SSD 6633 - SICEEP Darling Square - Mixed Use Residential Building within the South-East Plot

SSD 6633 Submission

FACADE SYSTEMS

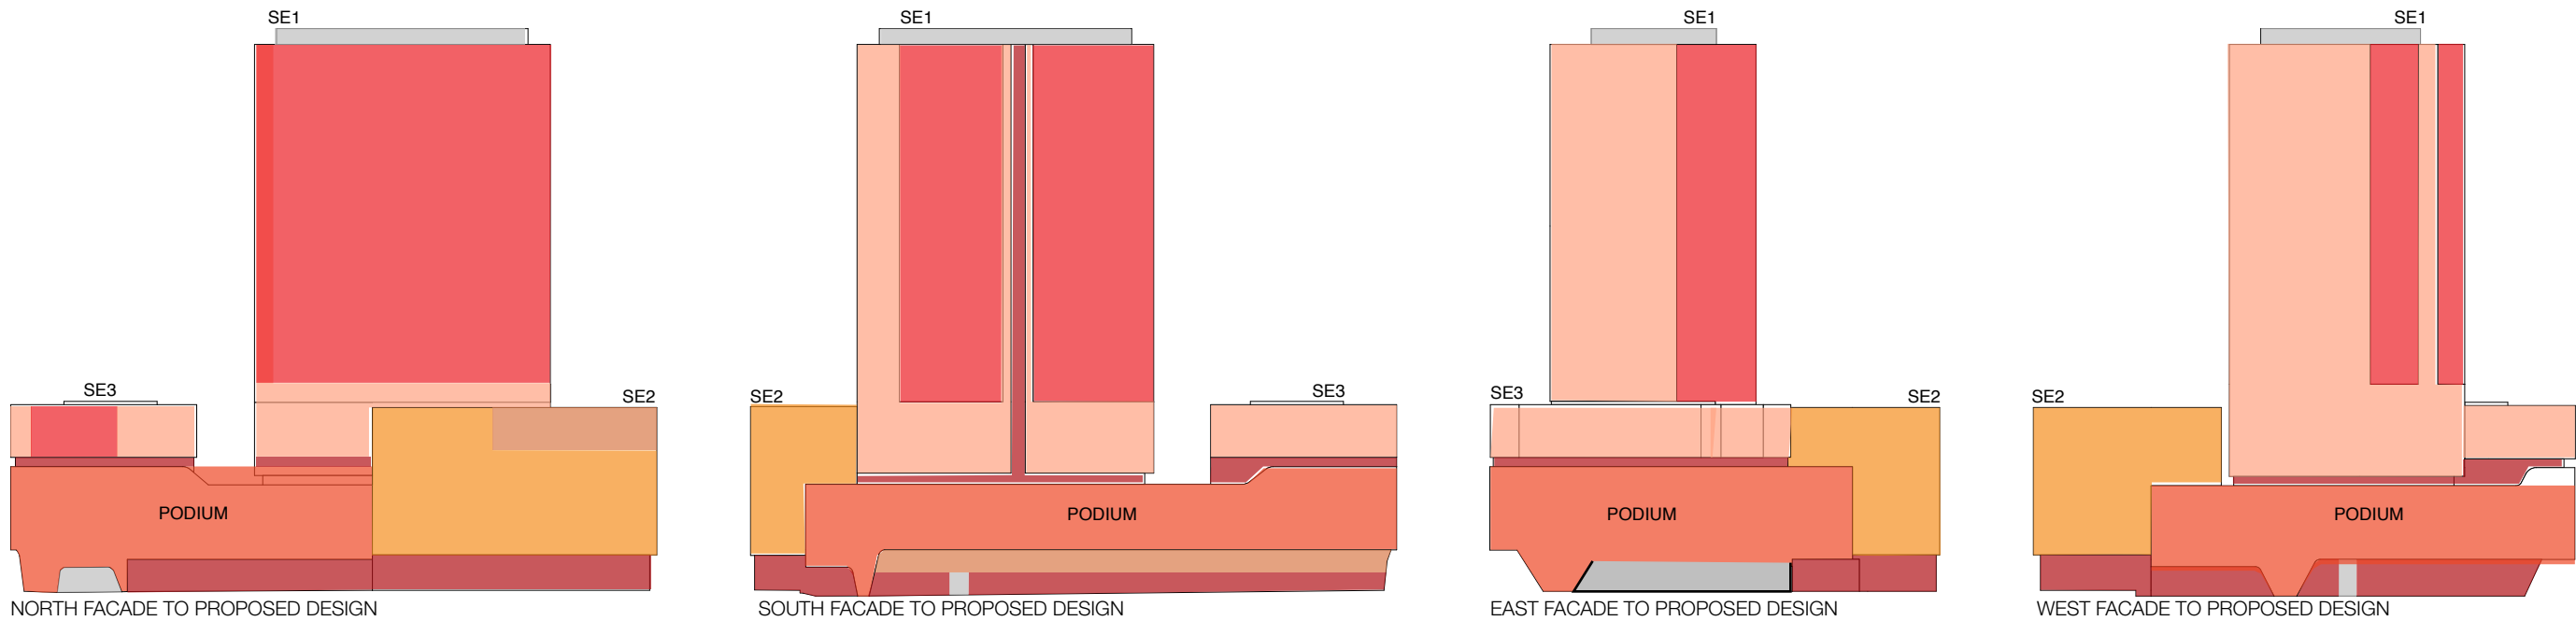
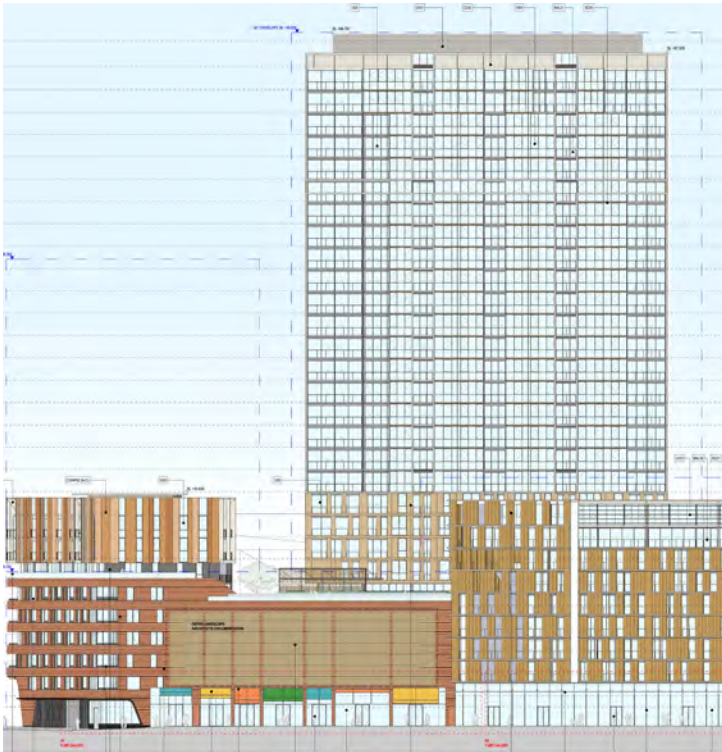
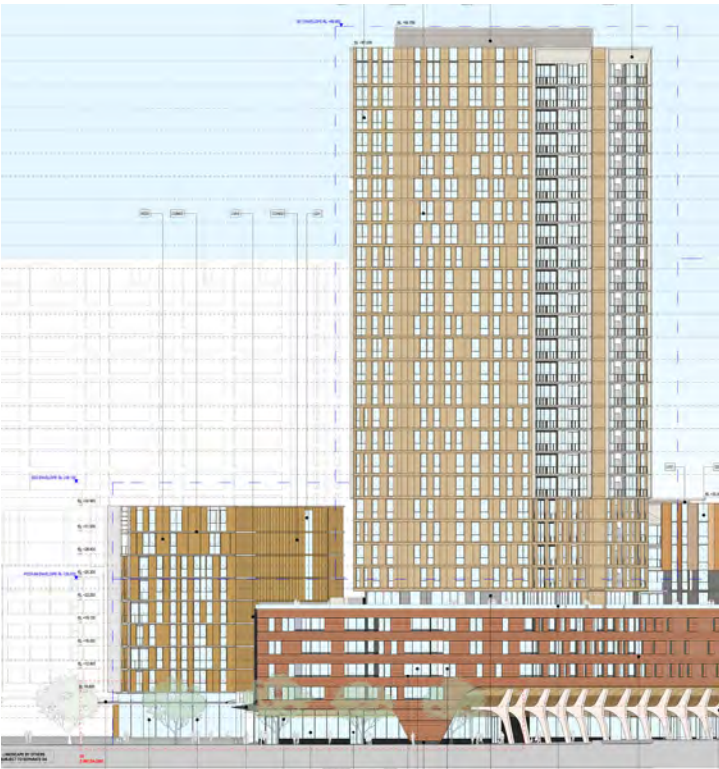
<p>EIS 3.4.2 page 37. Figure 21, building SE1 southern elevation</p> <p>There is no brise soleil.</p> <p>Appendix B Design Report 07A, p64</p> <p>Façade system diagram, building SE1 southern elevation</p> <p>There is a brise soleil.</p>	<p>The two documents are contradictory.</p> <p>The proponent has rushed this document and is still undecided about the materials and finishes.</p>
<p>On all facades of SE1, there is no use of any bright colours.</p>	<p>The proponent is overwhelmed by the task of designing a large residential building which is also attractive. The SE1 building appears to be commercial or institutional rather than residential.</p>
<p>EIS 3.4.2 page 42</p> <p>"The façade of Building SE3 is composed of a geometric collage blending autumnal tones to create a finely scaled screen of warm hues. "</p>	<p>The proponent is unwilling or unable to apply the genuine colour creativity which it displays in the small building SE3 in the much larger building SE1.</p>

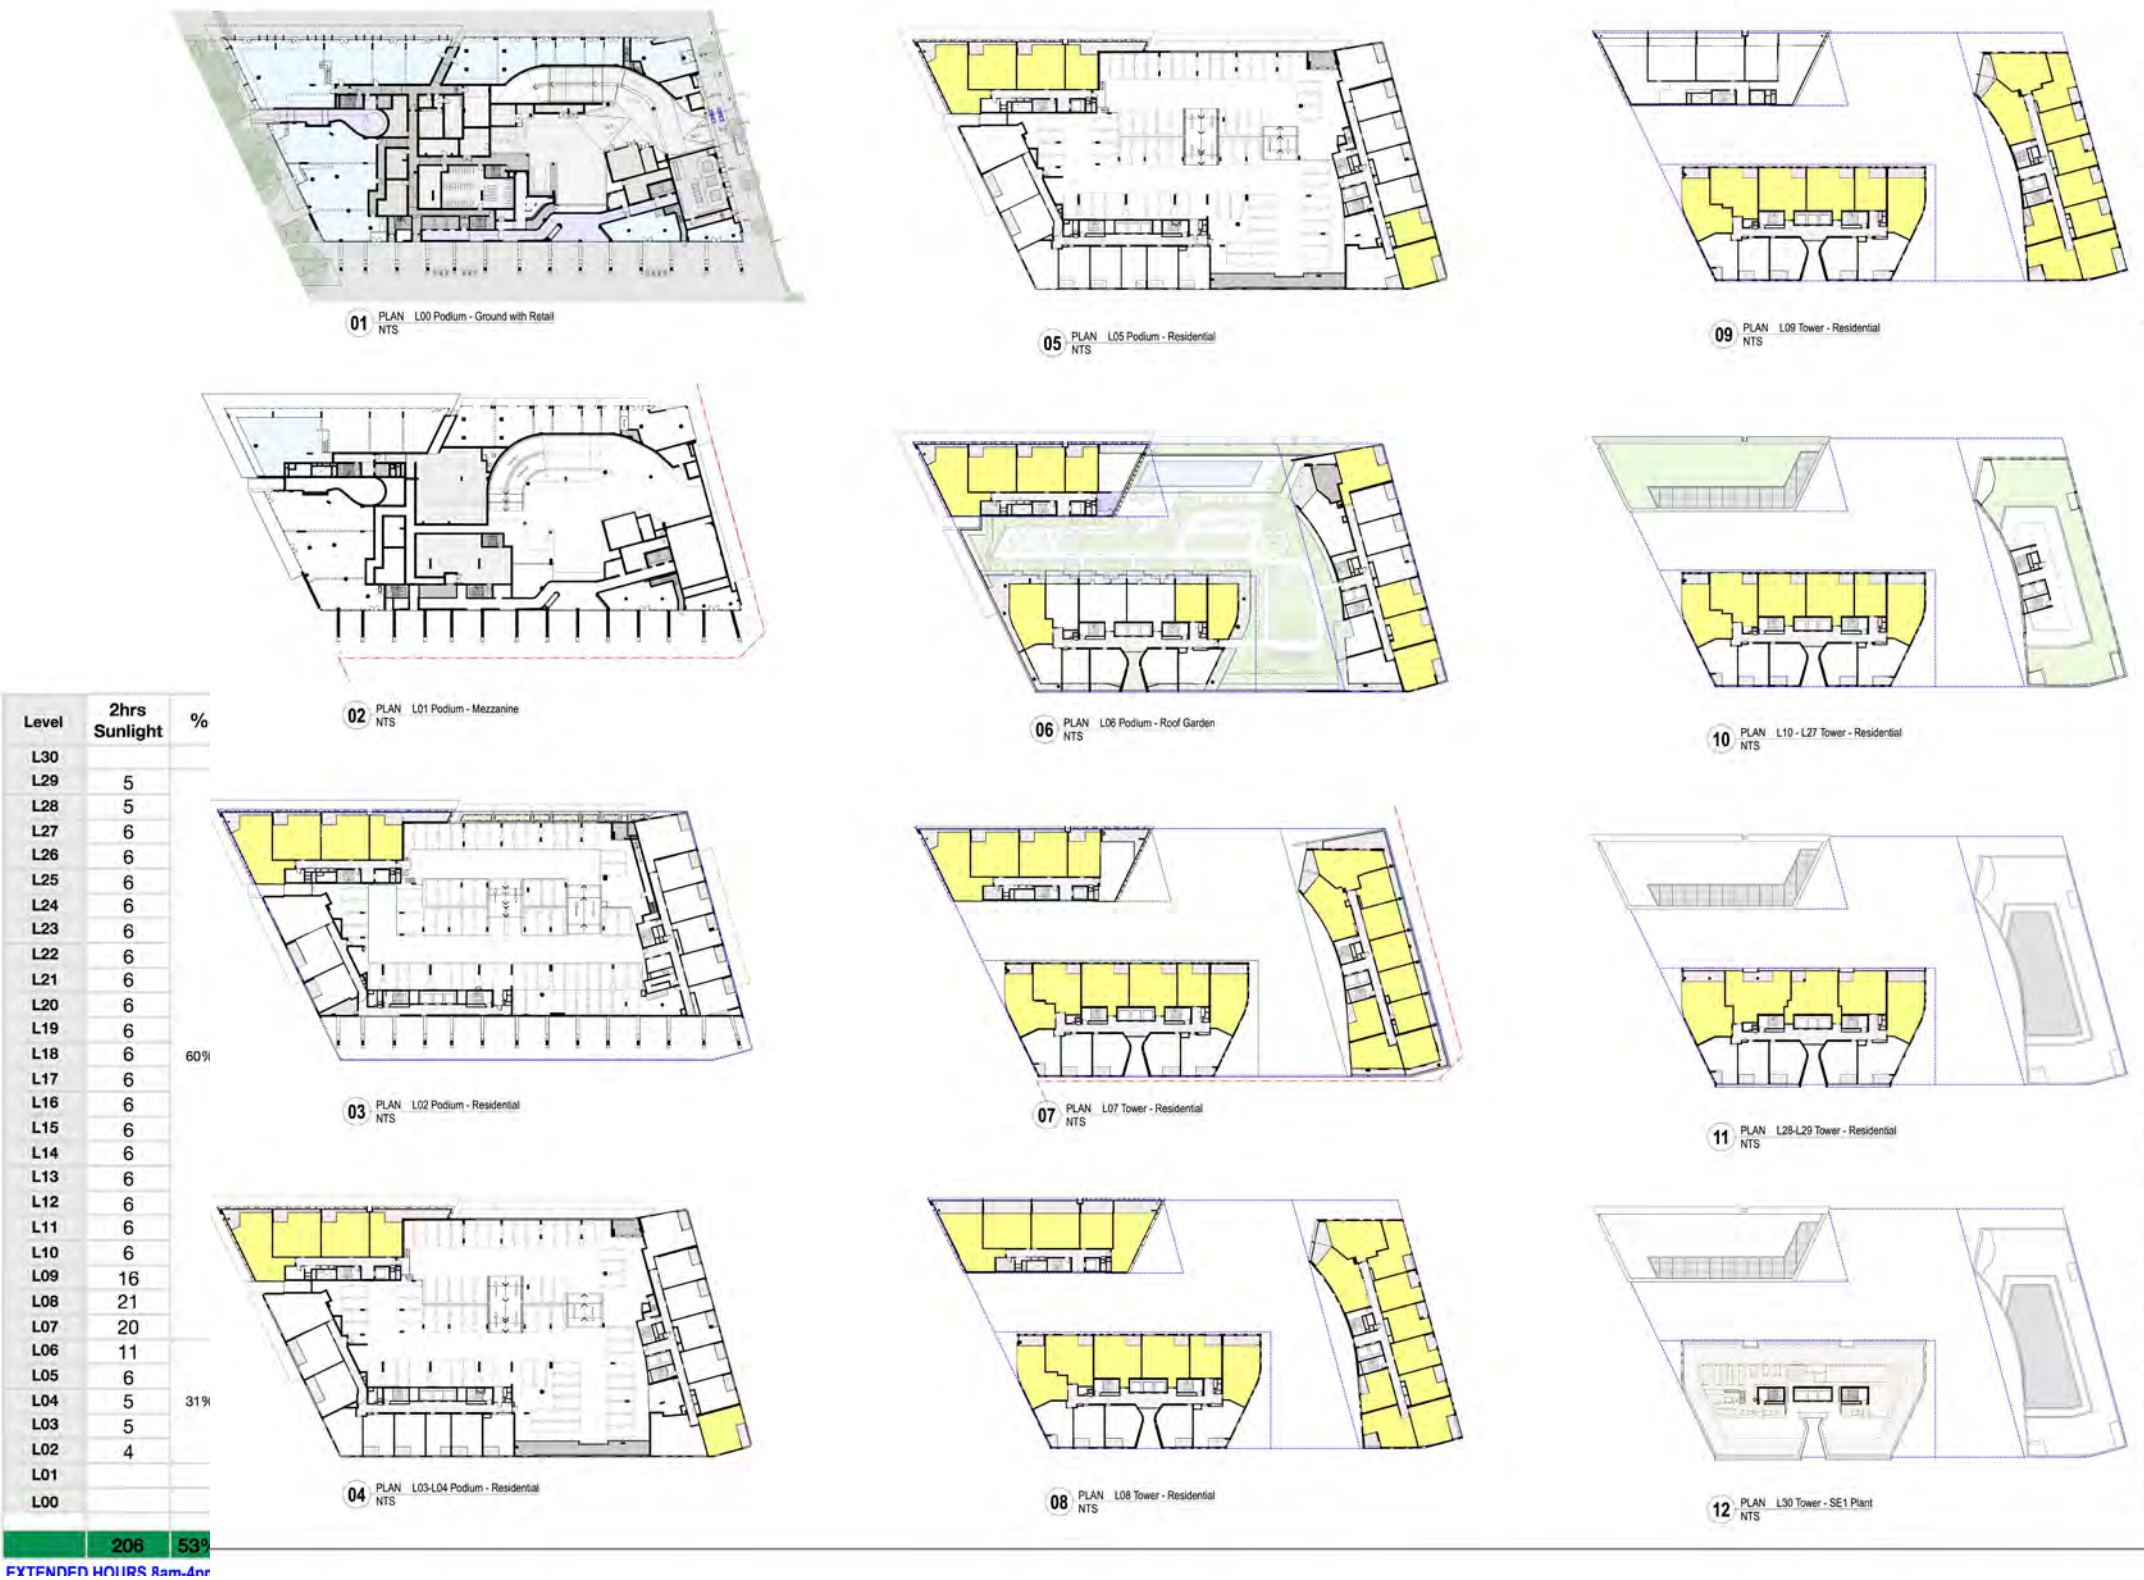
The Proposal	Comments by this Submission
<p>Appendix B Design Report 07A page 75</p> <p>"Overshadowing on the site comes from the adjacent Haymarket development (affecting the western facade and podium), and the recently approved Greenland tower. The Stage 1 Concept Proposal (SSDA 2) assumes an average of 70% of apartments for the entire precinct and 71% of apartments in the South East Plot would comply with the 2 hours of solar access to living spaces under the RFDC.</p> <p>Between the core hours of 9am and 3pm 47% (183 / 391) of apartments receive sunlight.</p> <p>Between the extended hours of 8 am and 4 pm the number of apartments receiving 2 hours or more solar access is 53% (206/391). The extension in time sees an increase of 23 apartments receiving 2 hours or more of sunlight. Detailed elevation shadow analysis is provided on the following pages showing the sunlight throughout the extended hours noted above.</p> <p>When the scheme is viewed in its Tower (L07 to L29) and Podium (L01 to L06) components the solar performance of the building is more clearly illustrated.</p> <p>The Tower component contains 290 apartments of which 174 (60%) achieve compliance.</p> <p>The Podium component contains a further 101 apartments of which 31 (31%) achieve compliance.</p> <p>Its important to note that the podium contains only 26% of the total apartments yet accounts disproportionately for 38% of the non-conforming apartments.</p> <p>The podium apartments have been designed to optimise their access to natural light whilst achieving high levels of both visual and acoustic privacy. The resulting solar performance outcome is a good result given the overshadowing of adjacent developments, and orientation of the podium."</p>	<p>There is no provision in either the Apartment Design Guide or the Residential Flat Design Code to consider hours other than from 9 am to 3 pm.</p> <p>It is pointless saying that the Tower is more compliant than the podium; what matters is the overall compliance. Of course, the podium, which achieves only 31% compliance, would be better suited to non-residential uses.</p> <p>It is pointless saying that an apartment has some natural light; any apartment which is not underground or completely internal will have some natural light. But natural light does not constitute solar access in terms of the Apartment Design Guide or the Residential Flat Design Code, which both refer to direct sunlight and not mere daylight.</p> <p>The inescapable conclusion is that the overall compliance during the relevant hours is only 47%, which is far below the figures of 70% laid down by both the Apartment Design Guide and the Residential Flat Design Code.</p> <p>It is pointless saying that a good result has been achieved in the circumstances of other approved overshadowing developments nearby. It is doubly pointless to say this when one of the developments is being carried out by the same developer as the current proposal. It is triply pointless to say this when the City of Sydney was opposed to developing four residential towers on the Haymarket site and the building envelopes for four towers were approved in the face of opposition by the City of Sydney.</p> <p>The only thing that matters is what result is achievable on that site and, as a consequence, whether that site is fit for human habitation to NSW standards on the lower levels.</p>
